25 August 2015

Our Ref RG/SPRUSTINGTON6.1
Your Ref A/23/15/OUT

Mixed-Use Development on Land south of A259 New Road and East of Brook Lane, Angmering, West Sussex

We write, on behalf of our client Store Property Investments Ltd to comment on the proposed development at the above site. Specifically, our comments below are in relation to the Supplementary Transport Report and revised Road Safety Audit Report (RSA1) uploaded onto Arun District Council's planning portal on the 16th July 2015.

Title
HIGHWAY ACCESS PLAN

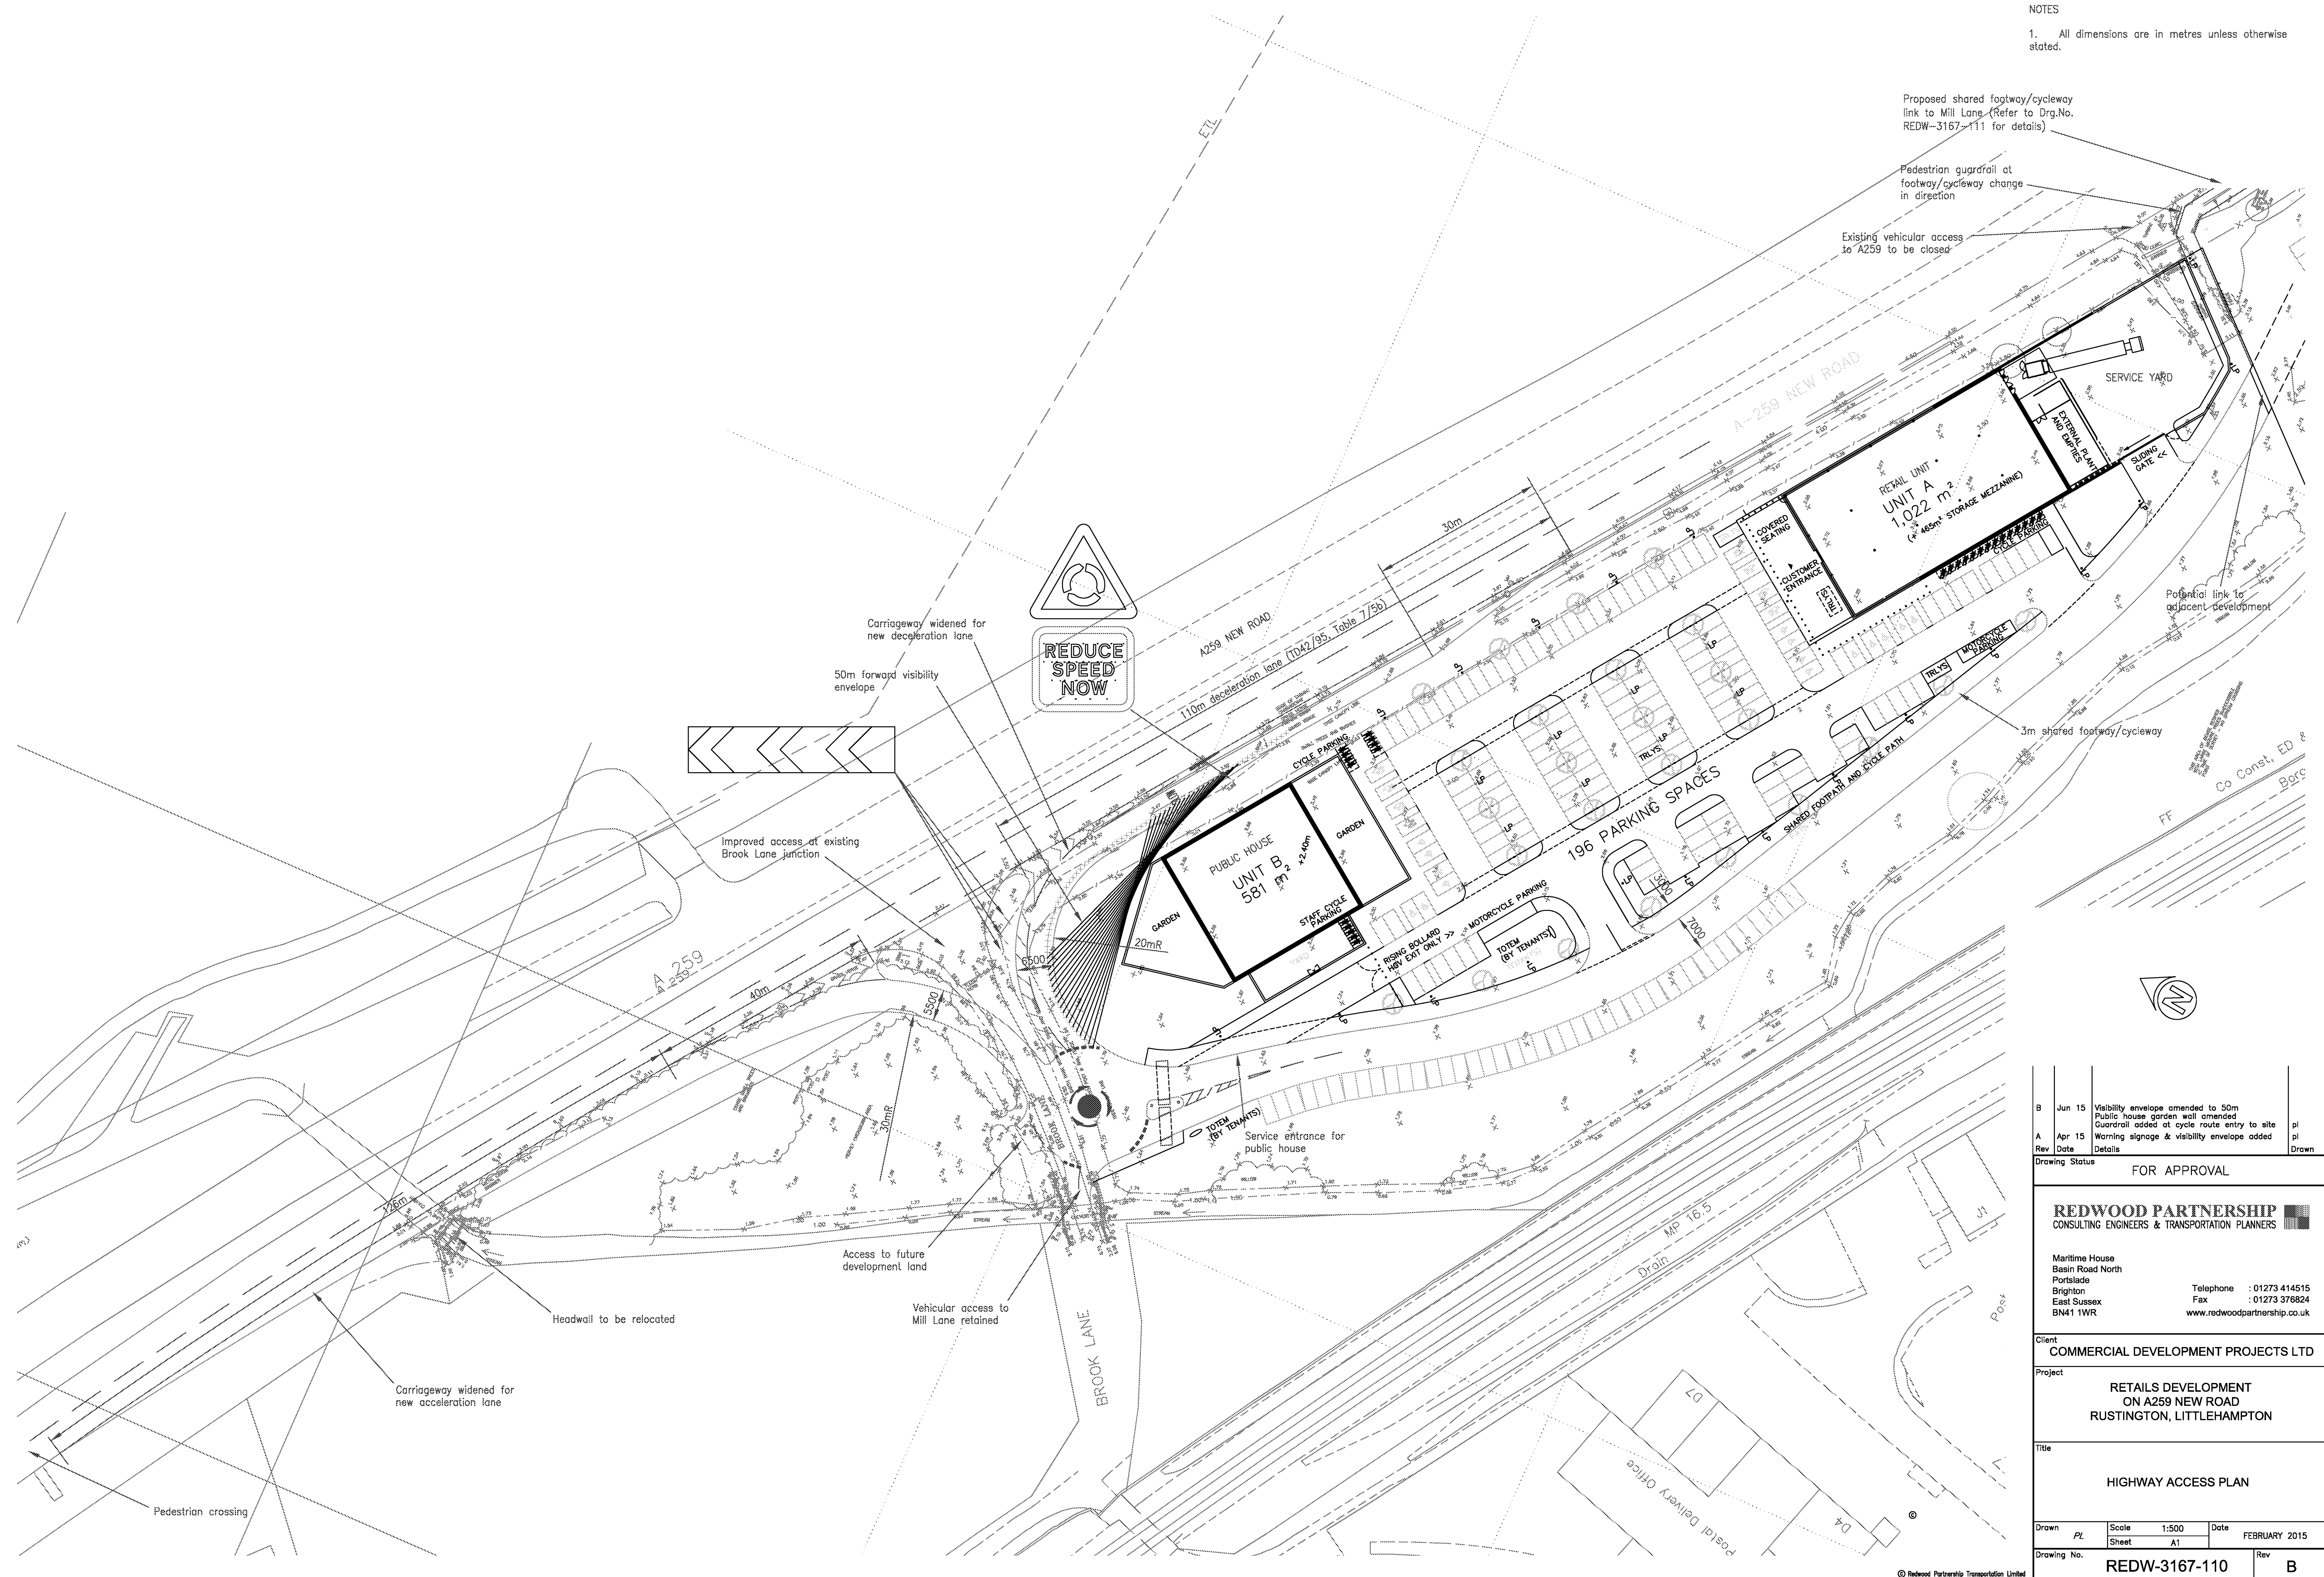
- The proposed site layout drawing REDW-3167-110 rev B attached to the Supplementary Transport Report illustrates forward visibility splays from the diverge lane into the site. The forward visibility splays begin approximately half way along the diverge lane and are shown as 50m long which appears inadequate given the speed cars are likely to be traveling at. In accordance with Table 3 from TD9/93 of the 'Design Manual for Roads and Bridges', a desirable minimum stopping site distance of 70m is required for a vehicle speed of 30mph. Given that the A259 has a speed limit of 70mph, it is considered to be highly unlikely that the speed of cars accessing the site would have decreased down to 30mph by this point and that a stopping sight distance of at least 70m is therefore required. The achievable visibility is restricted by the fence around the garden of the public house.

In combination with the reduced entry radius, the restricted visibility is considered to present a safety risk - a view supported by the submitted safety audit.
